Fire Marshal Division

Re: Campbell Pointe Townhomes Shed
130 Winston Rd.
Lillington, NC 27546

Application Number BCOM1901-0002

FLOOR PLAN

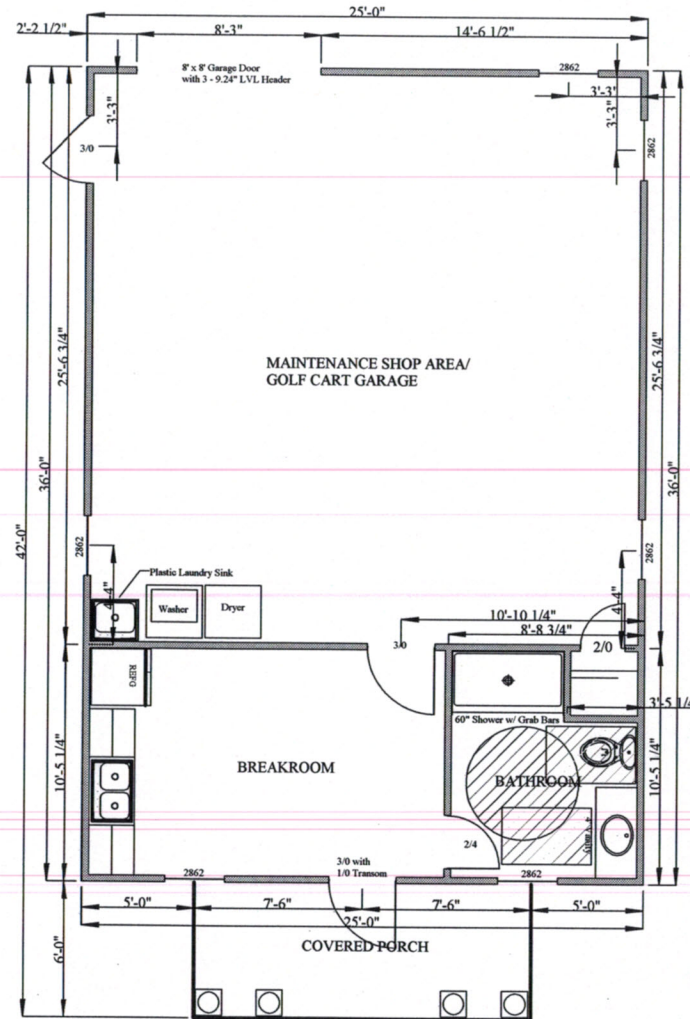
- **Fire Extinguishers**
 - Fire Extinguishers shall be 2A:20BC and shall be placed with a travel distance to not exceed 75'

- Fire extinguishers are to be mounted no higher than 5' above the finished floor.

- **1006.1 Illumination Required**
 - The exit discharge shall be illuminated at all times the building spaces served by the means of egress is occupied
 - Illumination level in all areas of the means of egress shall not be less than 1 foot-candle at the walking surface and shall have emergency power supply.
